Ribble Valley Borough Council  
Housing & Development Control

Your ref: 3/2024/0153  
Our ref: D3.2024.0153  
Date: 20<sup>th</sup> June 2024

Application no: **3/2024/0153**

Proposal: **Proposed demolition of garage and the gym behind it and construction of new dwelling (self-build) adjacent to the original bungalow and alterations to access to create new parking for existing dwelling.**

Drawing No: Sta.1129.3410.03B

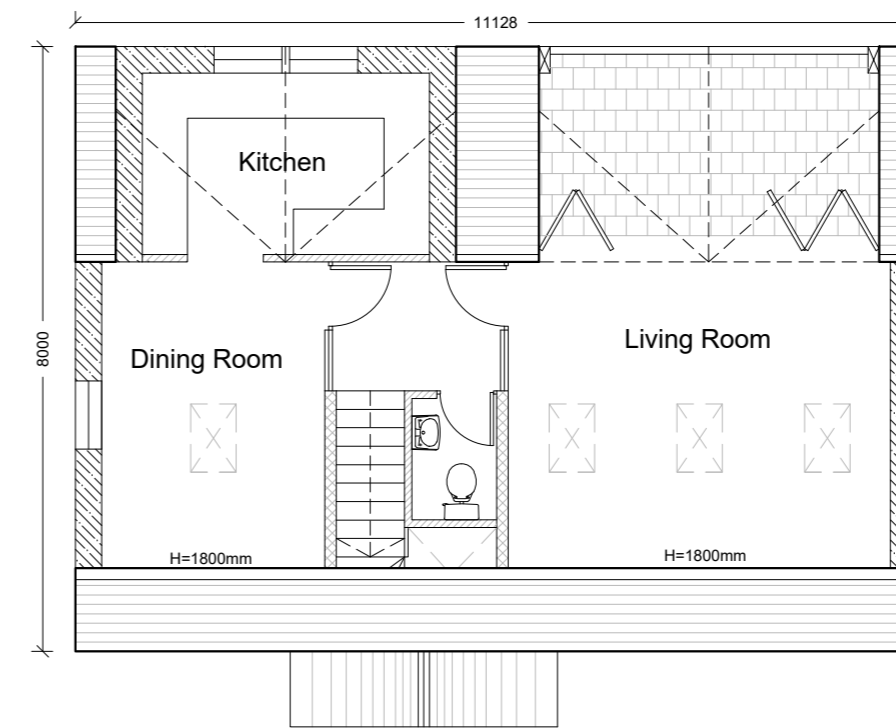
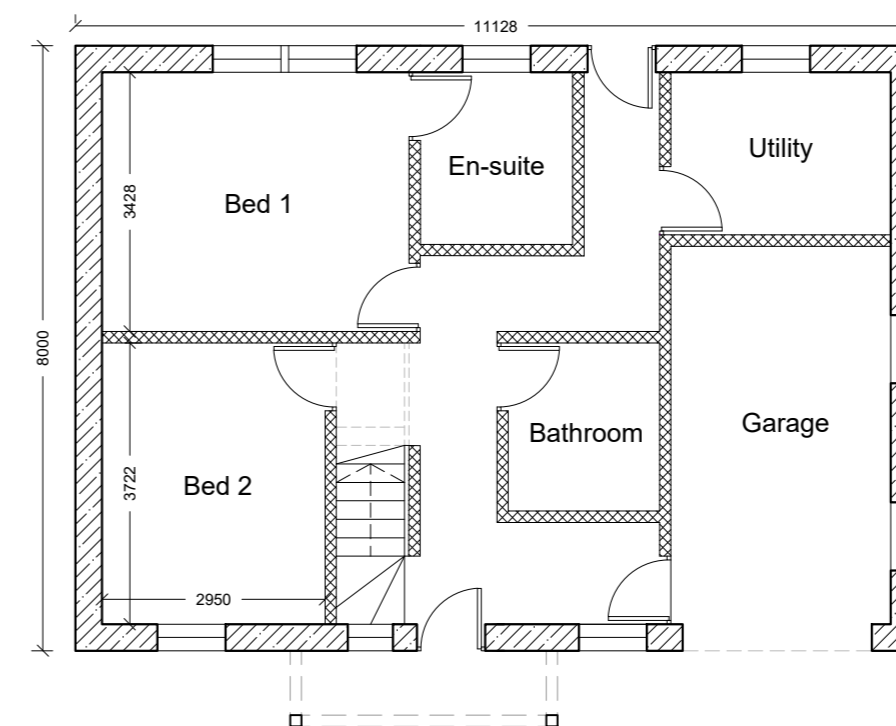
The LHA have reviewed GHA drawing number Sta.1129.3410.030 titled "Proposed Plans, Elevations and Site Plans" and note that the parking arrangements for the proposed and existing dwelling complies with the LHAs parking standards as defined within the Joint Lancashire Structure Plan.

The LHA will request that a minimum of one car parking space for the proposed dwelling has access to an electric vehicle charging point and some form of cycle storage provision is provided.

2. The development hereby permitted shall not be occupied until such time as the parking and turning facilities have been implemented in accordance with GHA drawing number Sta.1129.3410.030. Thereafter the onsite parking provision shall be so maintained in perpetuity.

3. Prior to first occupation the dwelling shall have an electric vehicle charging point. Charge points must have a minimum power rating output of 7kW, be fitted with a universal socket that can charge all types of electric vehicle currently.

4. Garage wall hanging cycle storage suitable for 2 bicycles shall be provided within the garage.
